Claire Dunne, Oral Hearing Metrolink Project, 27th February 2024, The Court Dalcassian Downs Glasnevin

Drawing Title  
**Figure 14.2 Groundborne Noise from Tunnel Boring Machine**  
Sheet 1 of 7

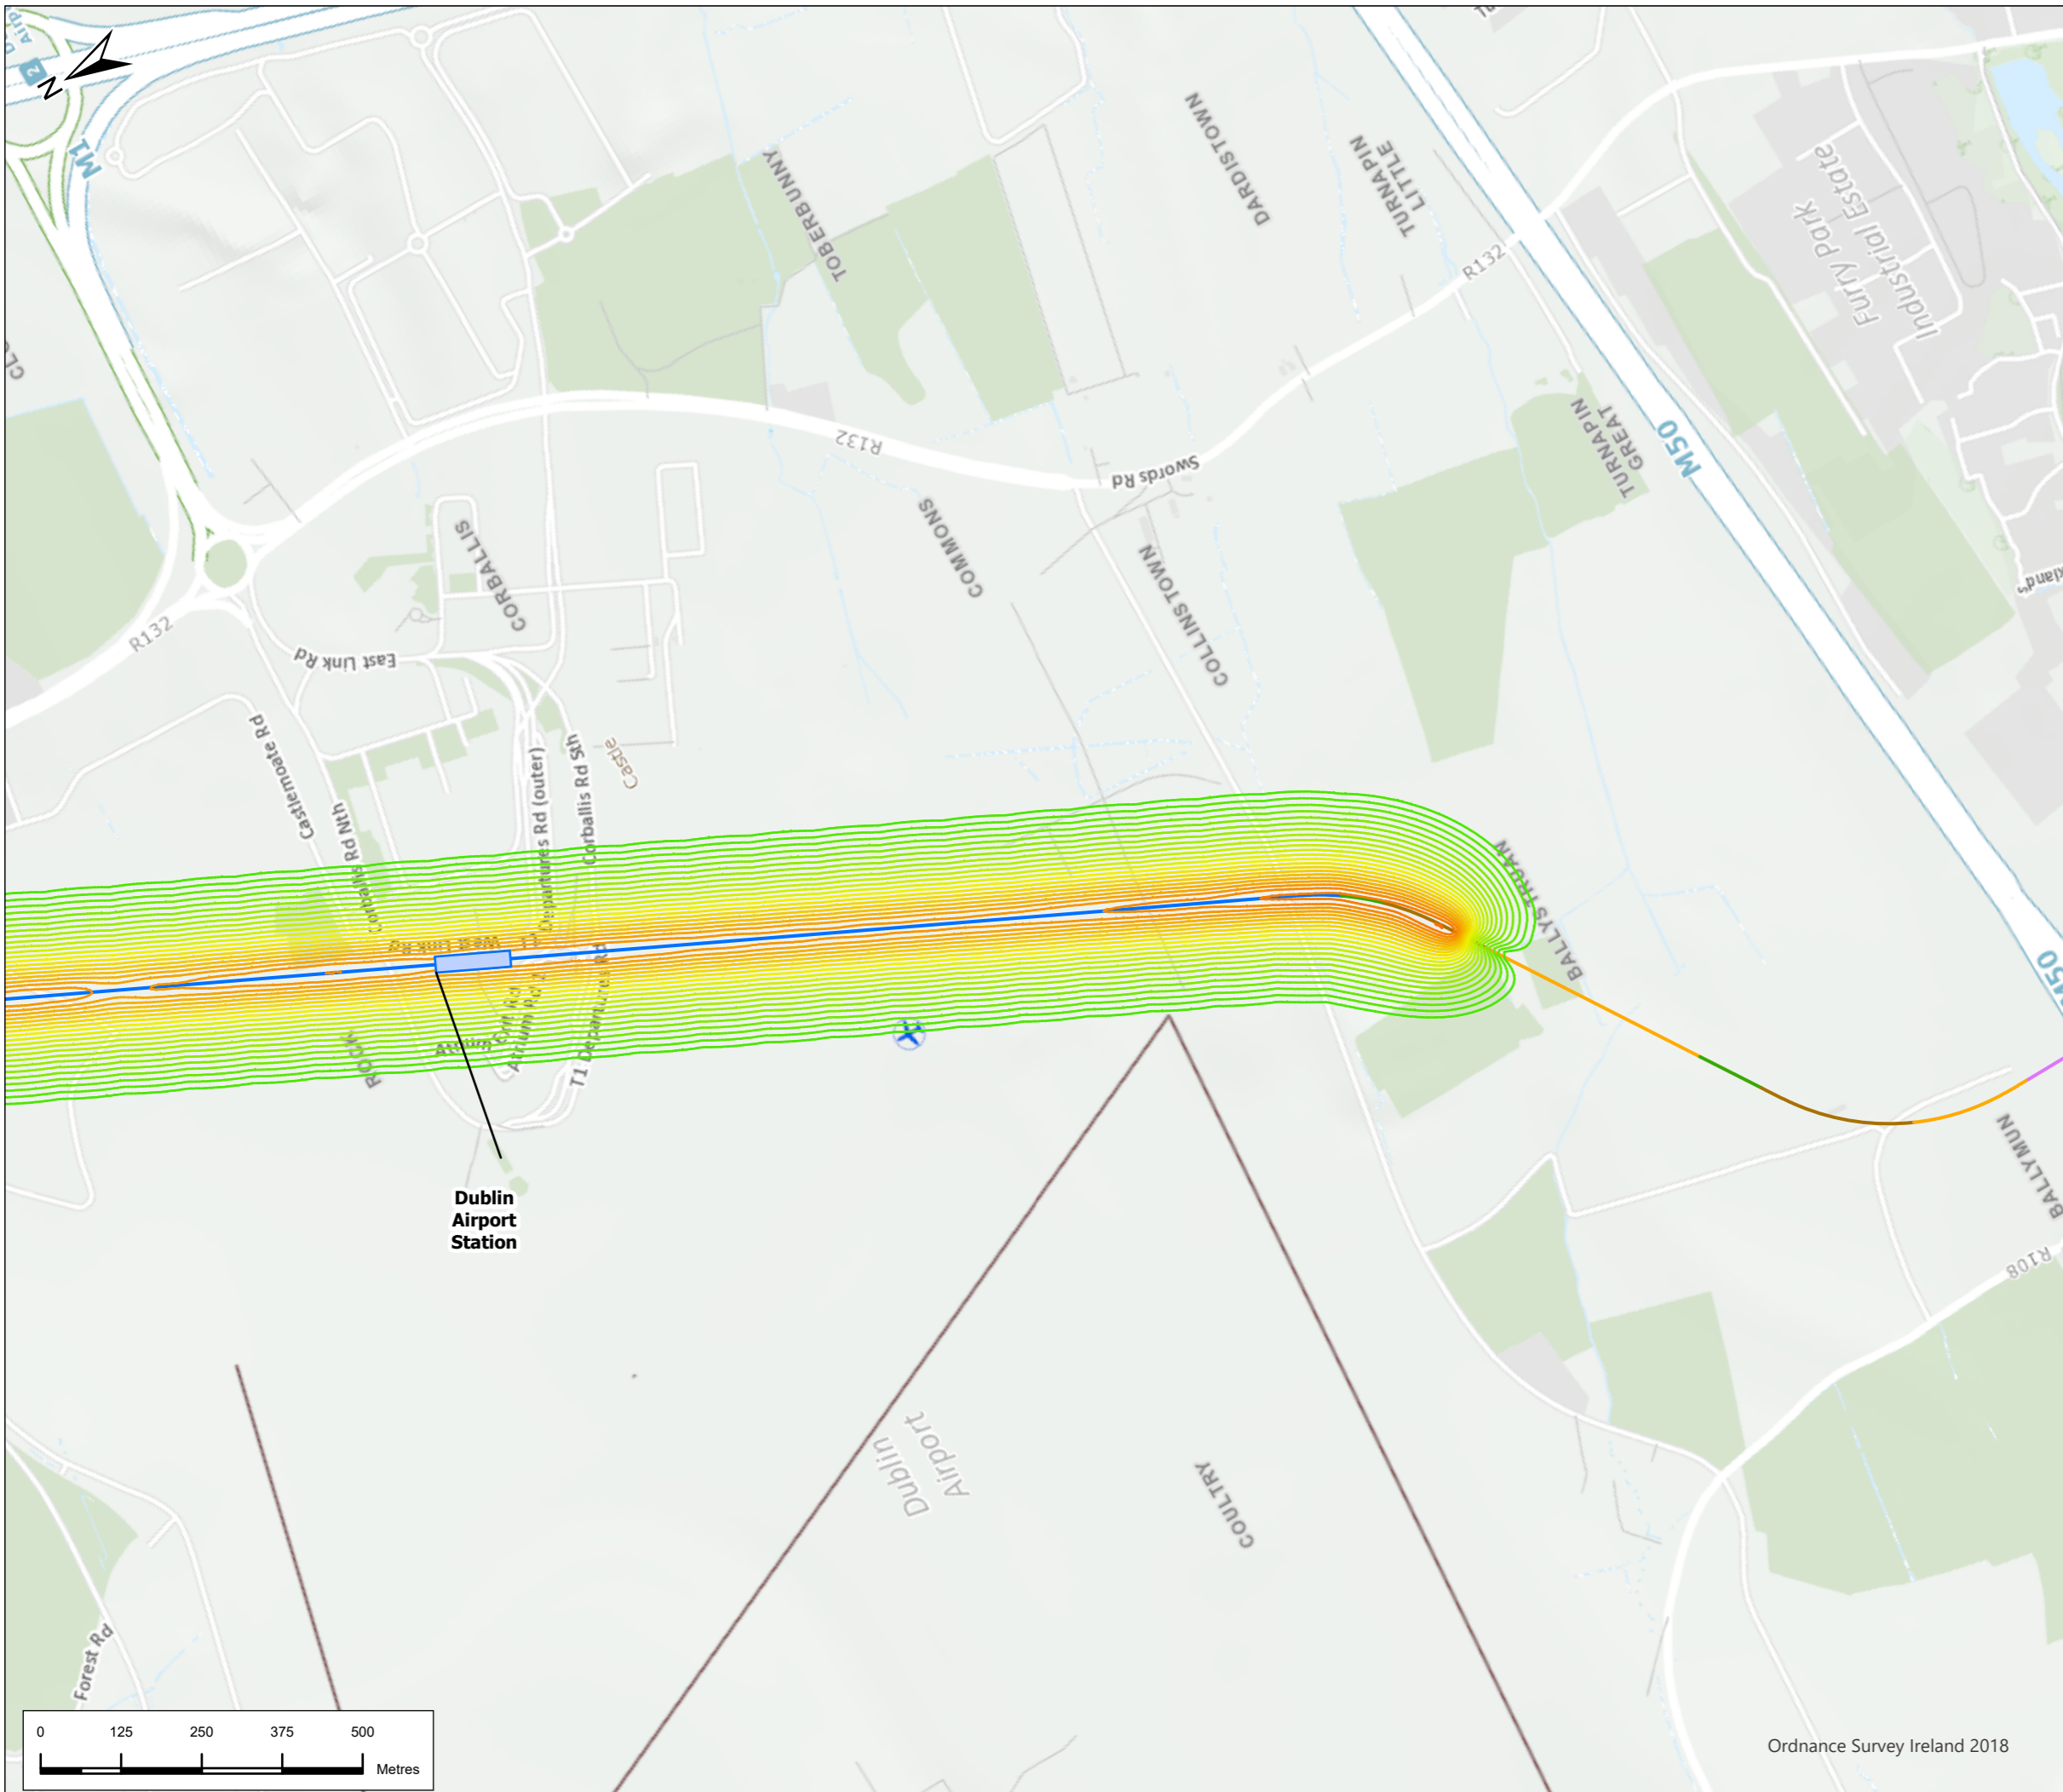
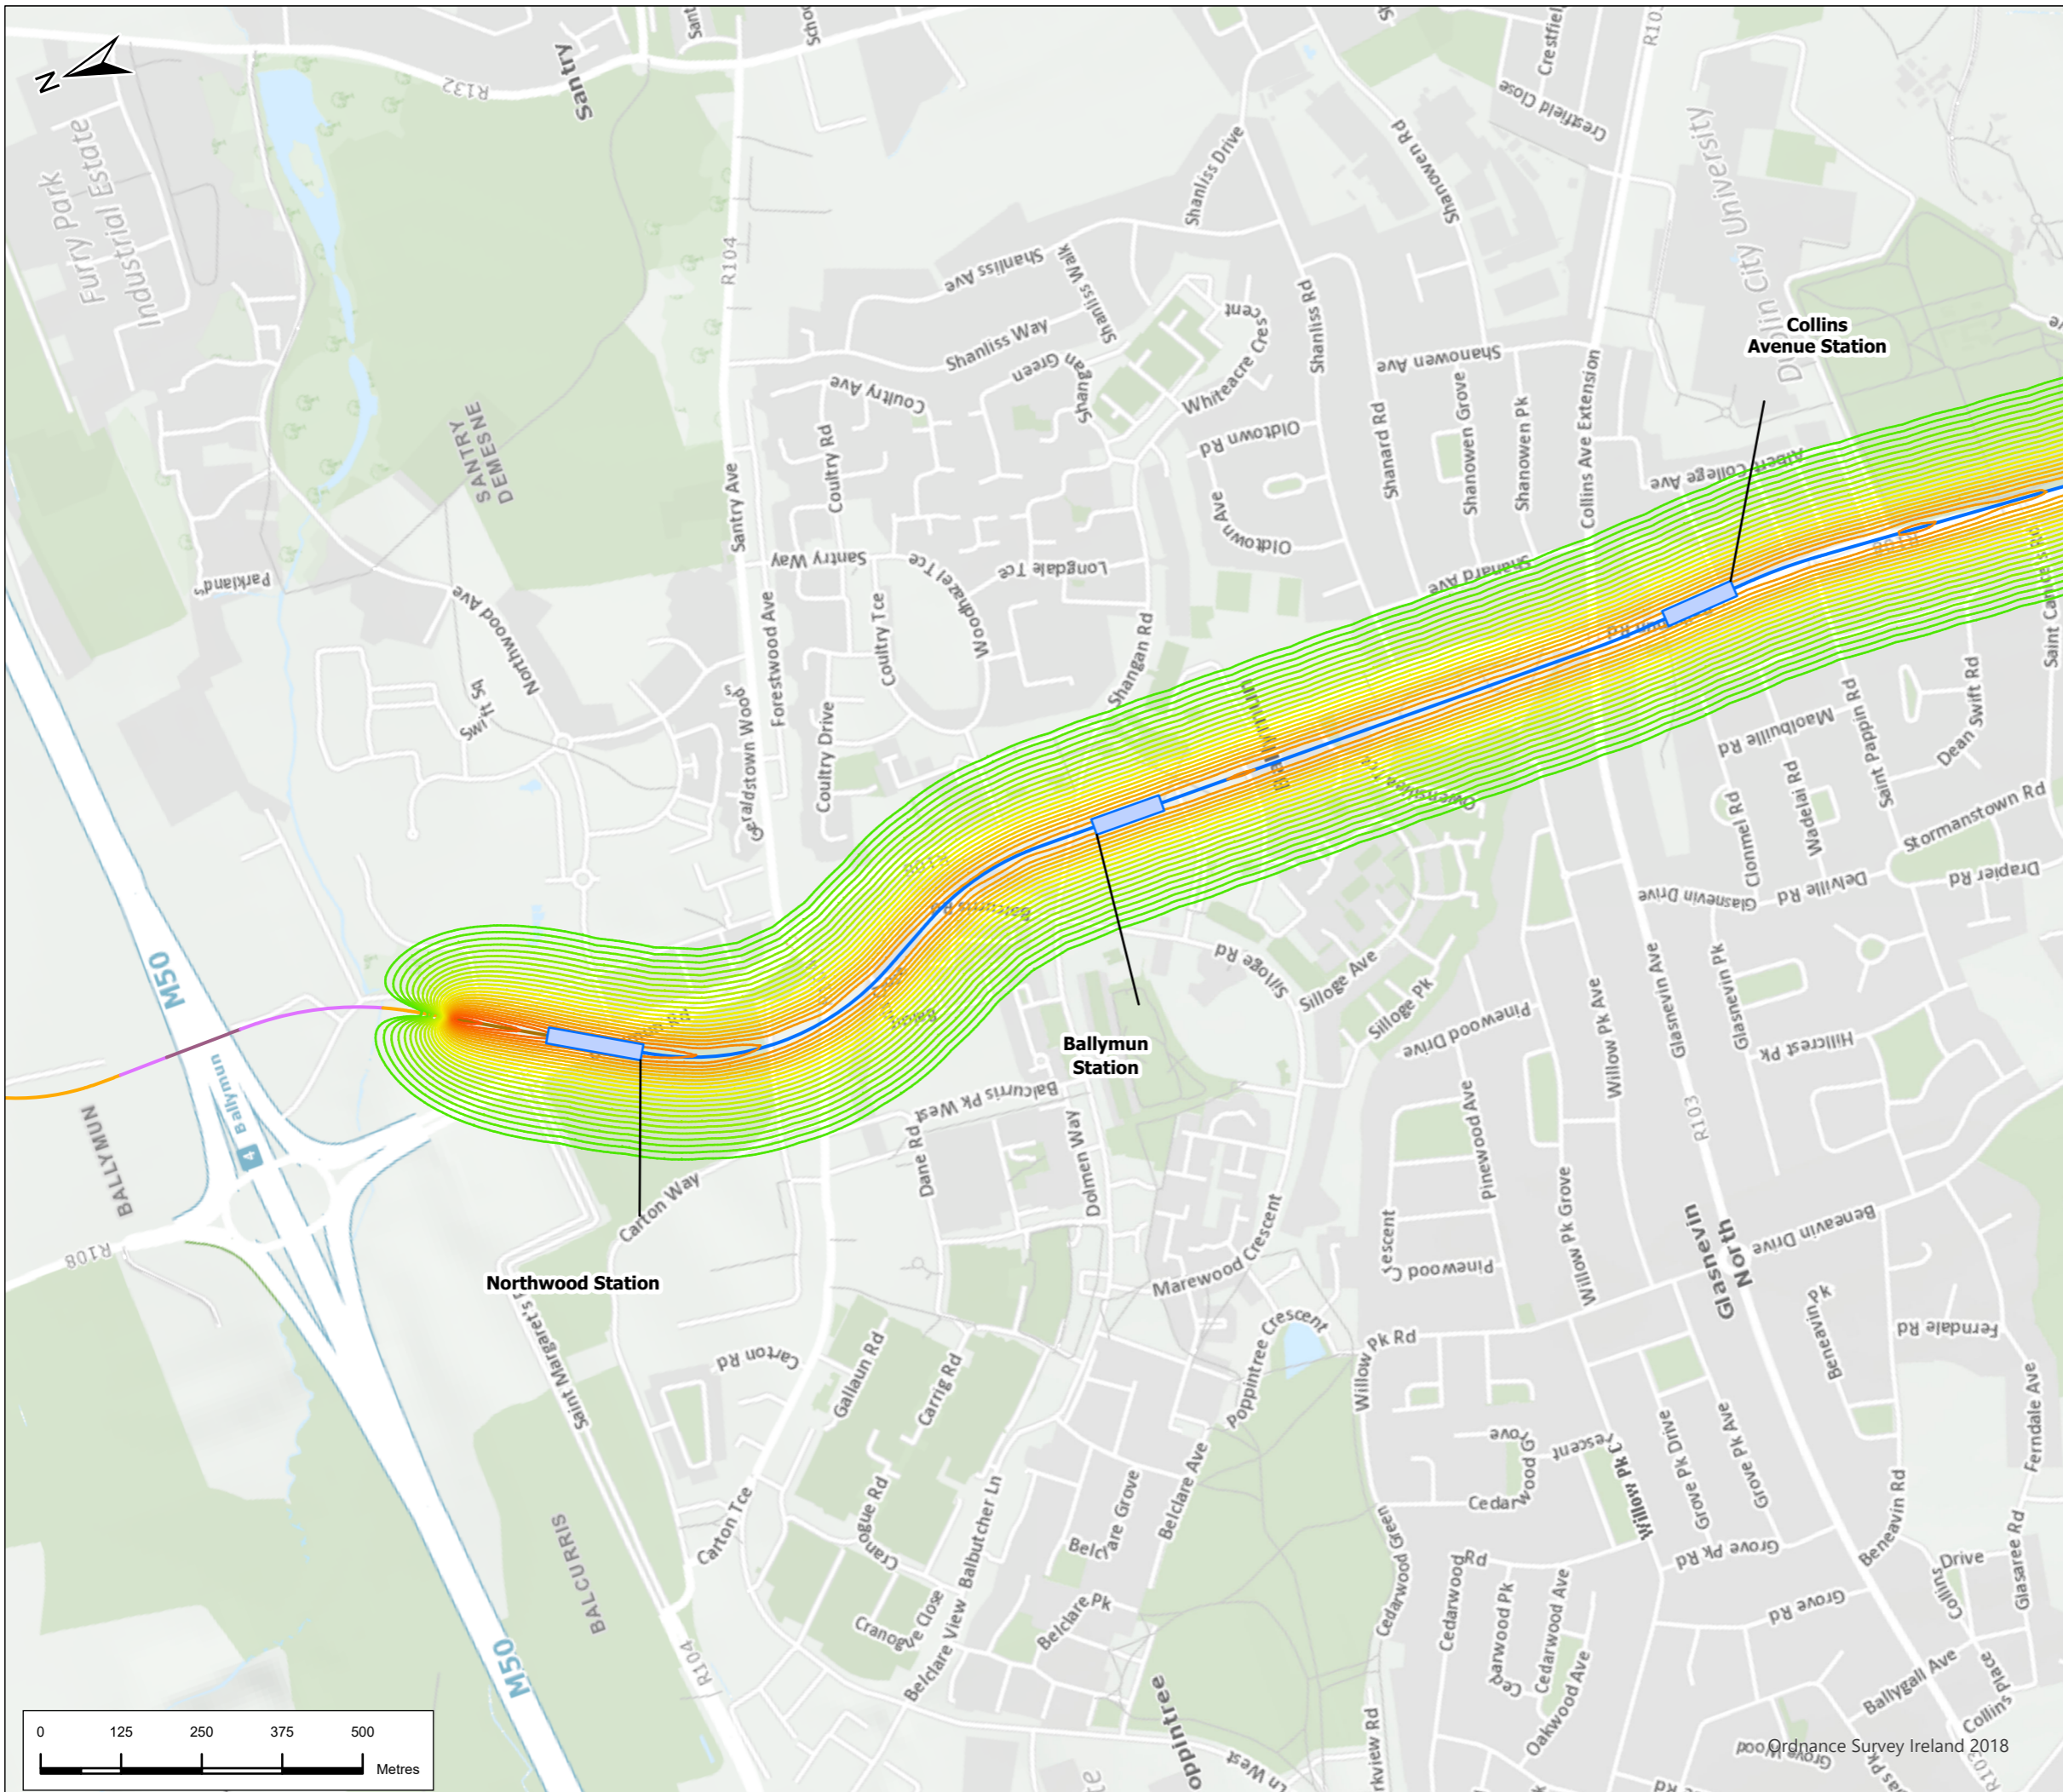
In response to my query in relation to groundborne noise and vibration you conceded that the groundborne noise while the TBM is passing below the apartment will be 49 dB, above that the threshold level of 45 dB. This will have a significant impact on the health and well-being of residents. You mentioned that TII will undertake advanced consultation and stakeholder engagement to prepare people for the passage of the TBM. What exactly does TII propose to do to minimise the impact on residents during this time? In terms of relocation how will you be able to guarantee relocation within the same area with the current rental crisis?
